NSW National Parks and Wildlife Service

Your ref: SSD-21342738
Our ref: DOC26/71406

Thank you for notifying the NSW National Parks and Wildlife Service (NPWS) of the modification to state significant development SSD-21342738, being for the Expansion of DCI's Eastern Creek Data Centre, located at 90 Peter Brock Drive Eastern Creek.

13 February 2026

original	scale	drawn	project no.
a0	1 : 500	ab	4666
drawing no.			
S02-AR-00-DRG-DEM-0108

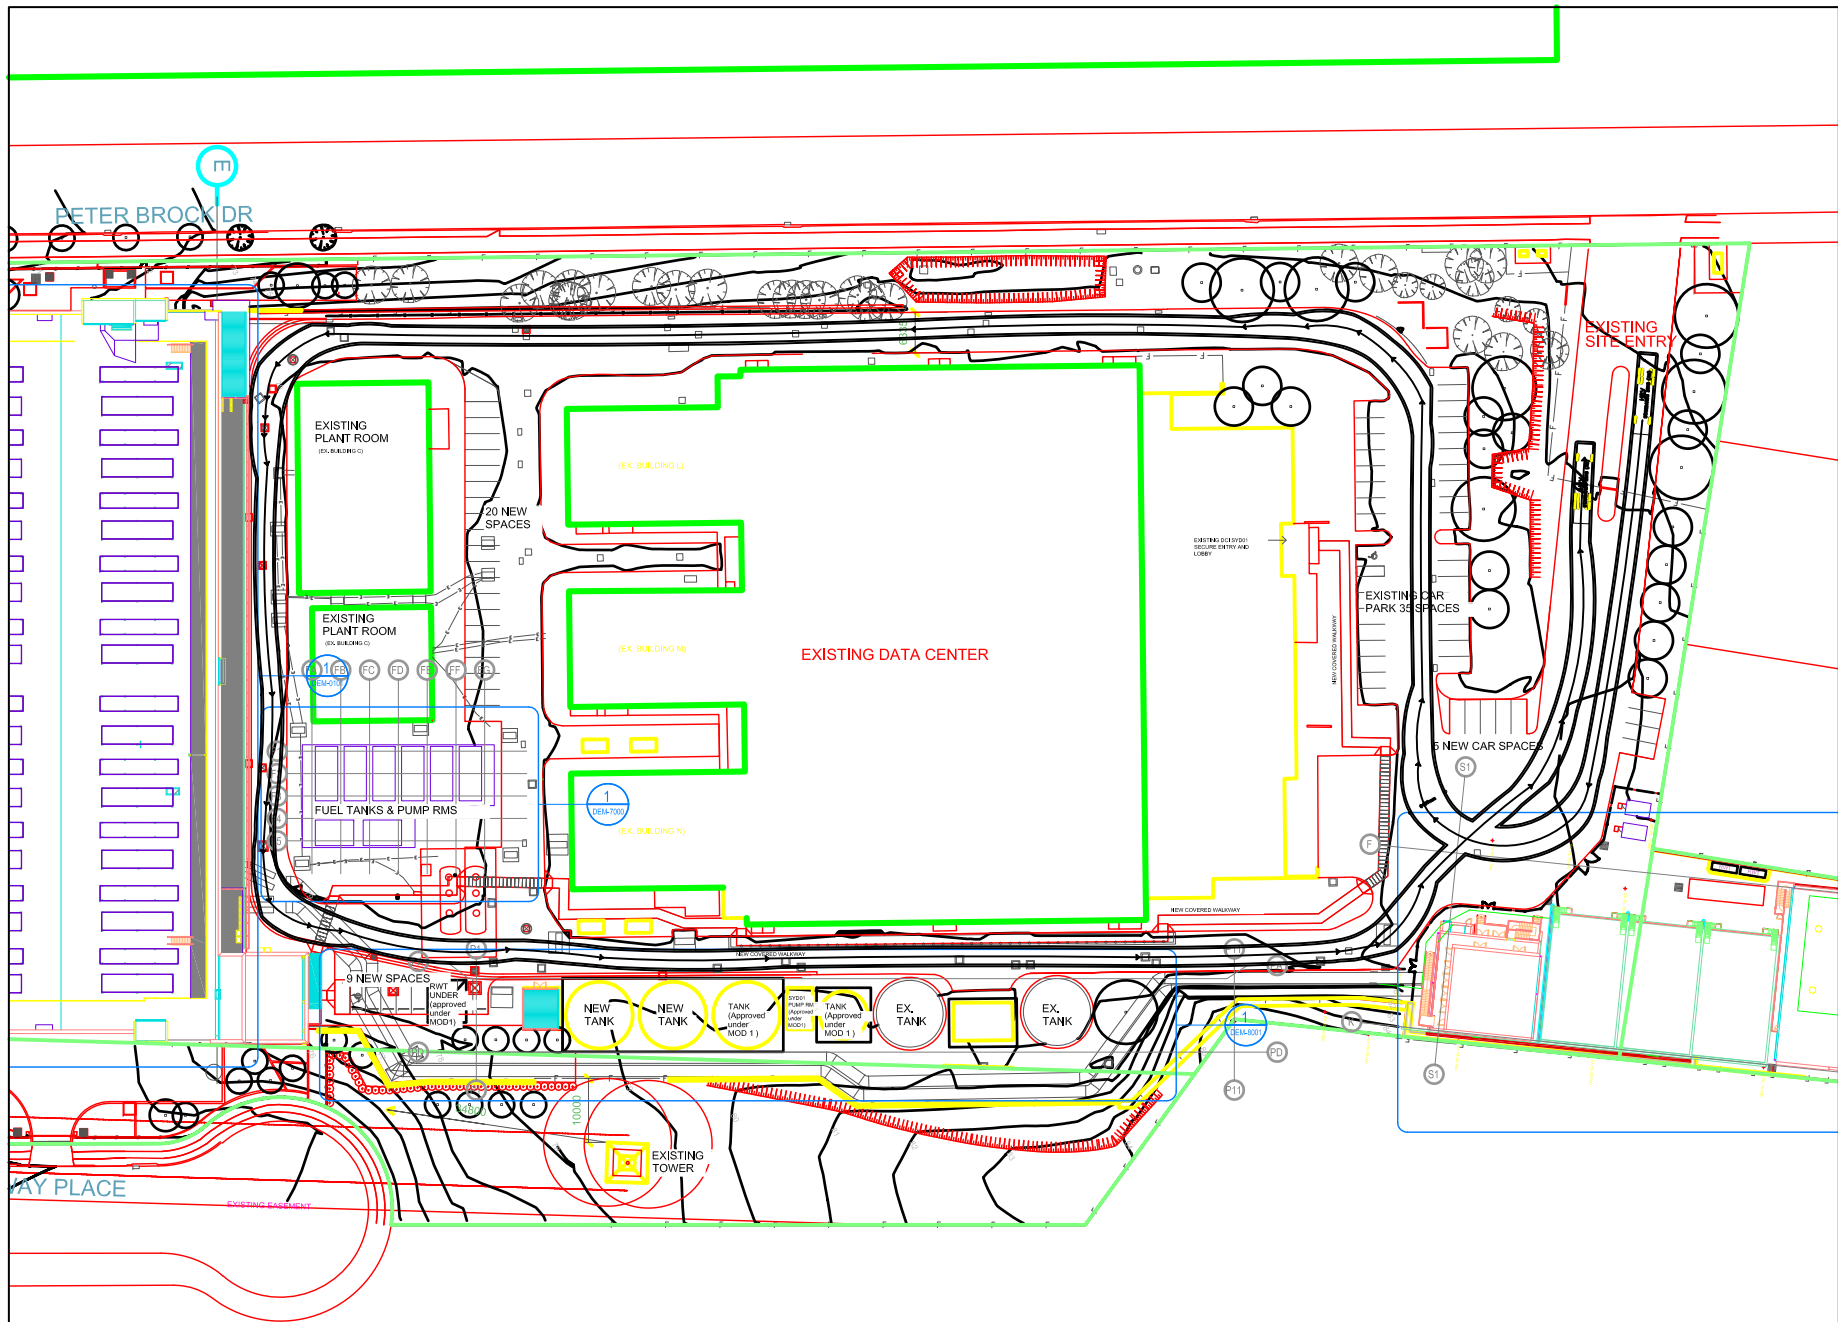
- NPWS is also concerned regarding potential direct impacts to the Reserve resulting from the additional excavation and construction of the high retaining wall on the property boundary. The plans are not clear what the offset from the Reserve's boundary will be. For example, the revised *Appendix A – Architectural Plans* in the substation's cross-sections on Drawing no. ar—2620 do not indicate the distance to the property boundary. *Appendix C – Revised Civil Design Plans* also do not indicate the separation, but it appears (from Drawing no. SHT-S02-CI-00-DRG-ACR-0503) to be much less than half a metre. This is not sufficient to allow construction works to remain on the development site.

- Revised plans are prepared, increasing the separation of the substation from the property boundary to enable construction of the retaining wall to occur without the need for any encroachment or additional works in the nature reserve.

2 GENERAL ARRANGEMENT PLAN - SUBSTATION  
1:200 @ A1

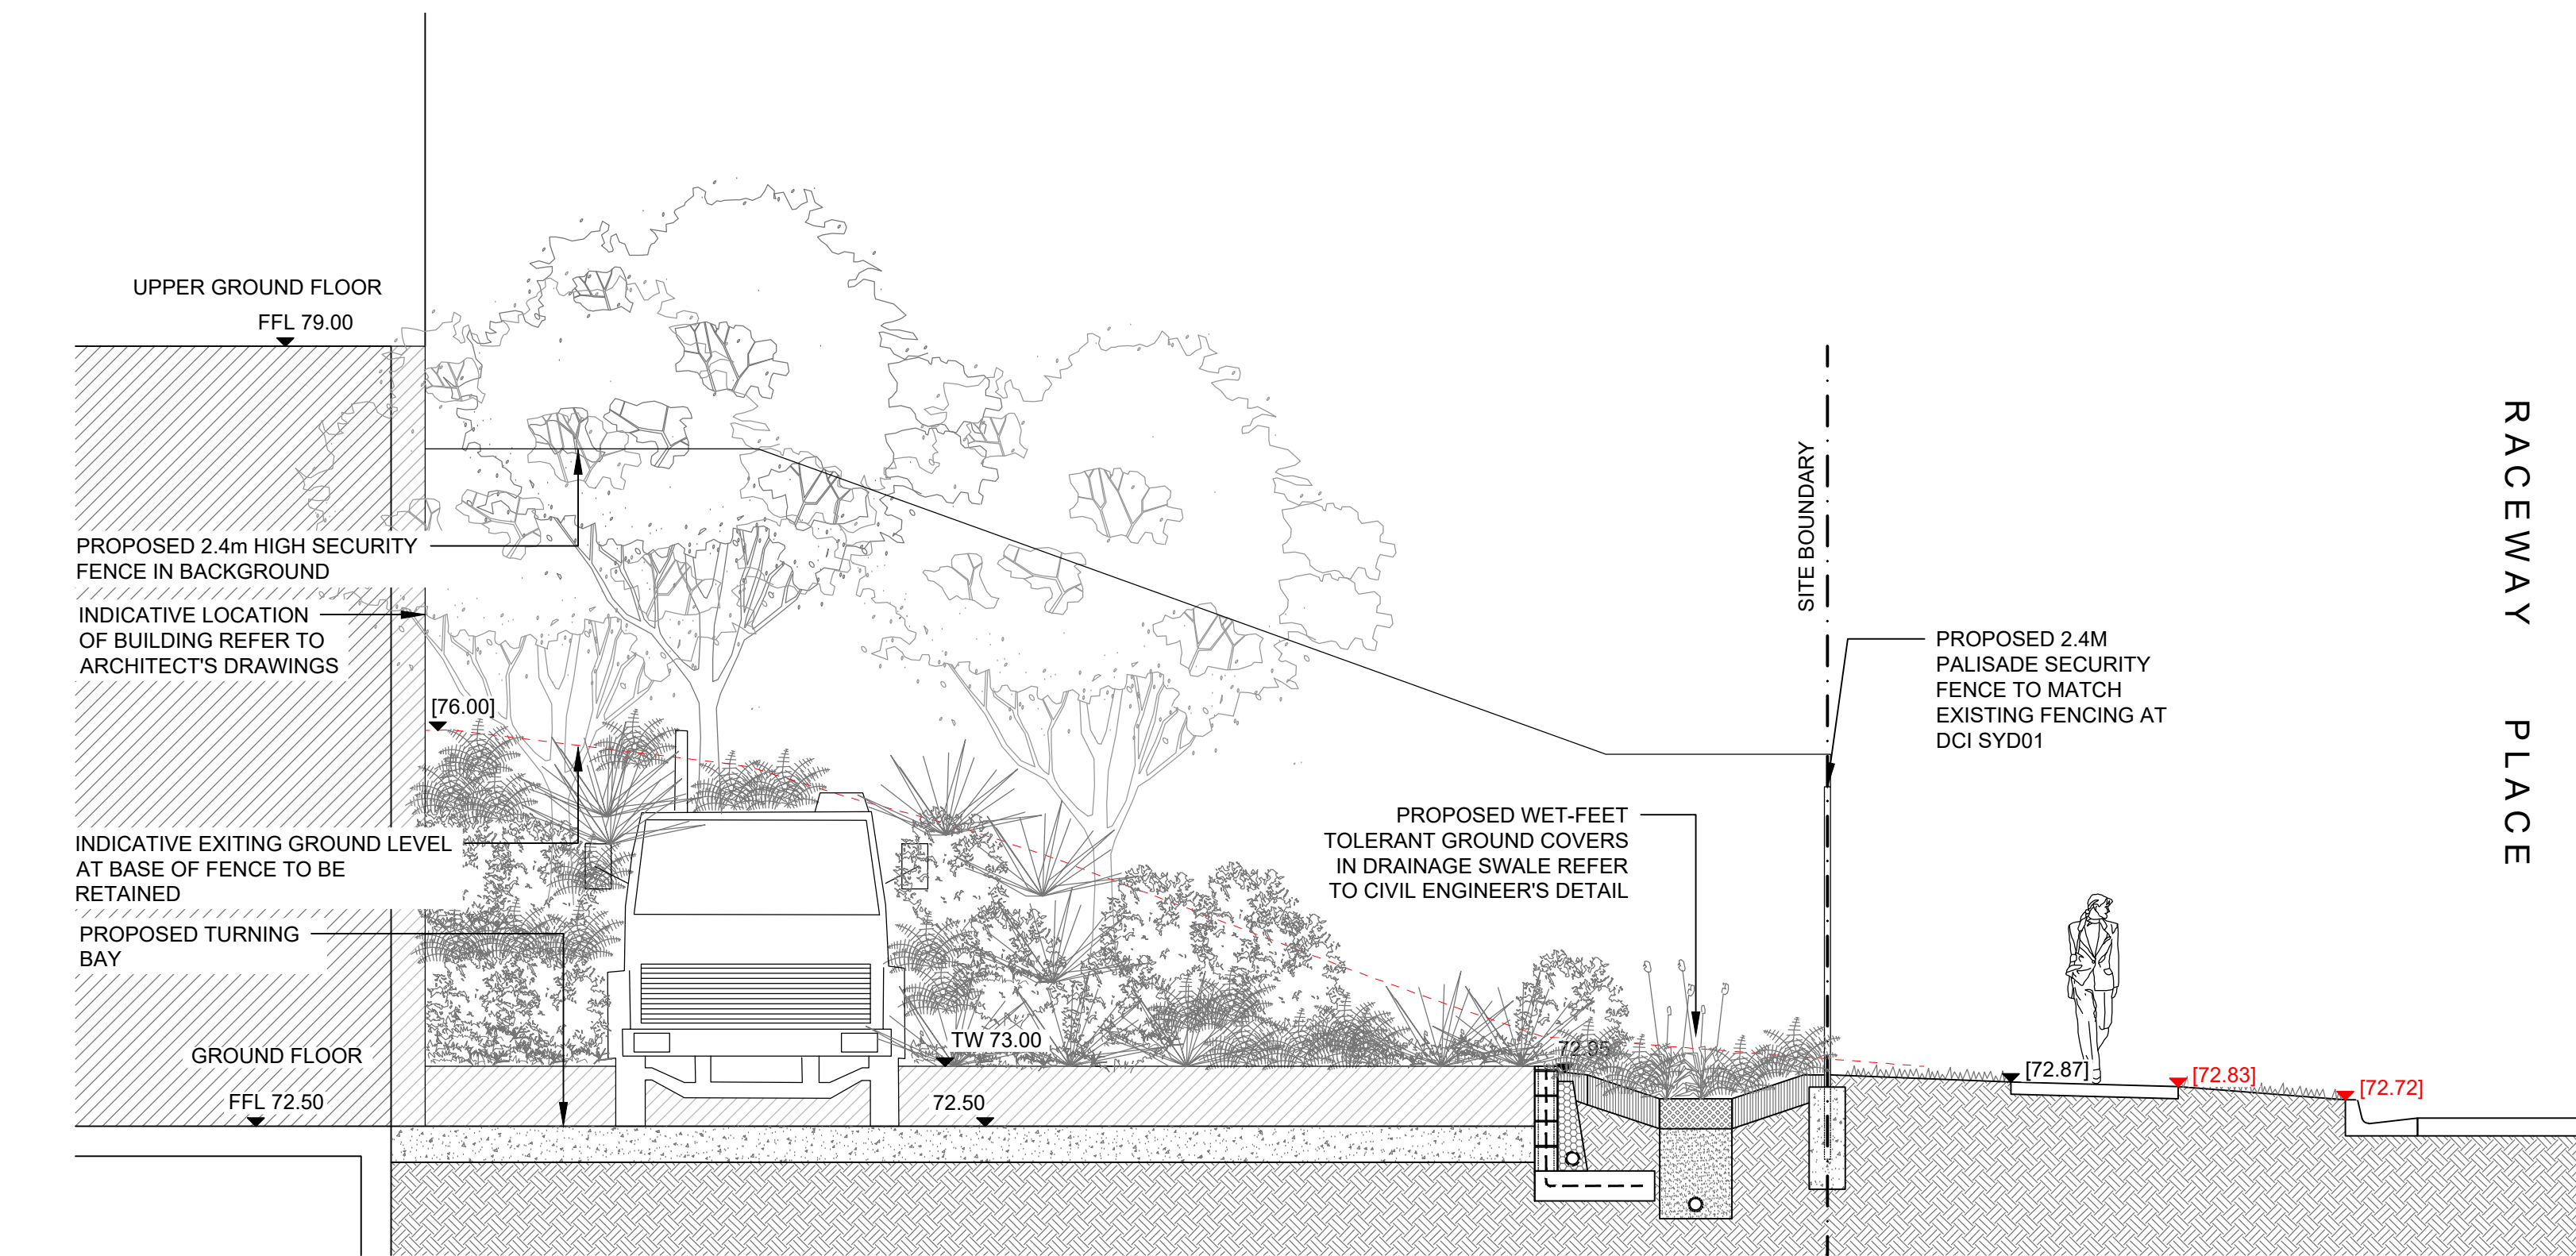
- One concern relates to the fact that the excavation will extend to an area where several trees currently grow in the Reserve near the boundary. These trees are not depicted in Drawing no. SYD02-L-A-03-0 of *Appendix B – Revised Landscape Design Plans*, and so it is unclear whether there will be ground disturbance in these trees' root zone or if the works will otherwise affect the trees' long-term viability.

- An arborist report on the potential impact to existing trees in the Reserve of the proposed additional excavation and extended retaining wall.
 - The additional impacts on the Reserve (and any proposed additional temporary encroachments) be considered as part of SSD-21342738 (noting that this would be subject to the NSW Minister for the Environment providing landowner consent under section 23 of the Environmental Planning and Assessment Regulation 2021).
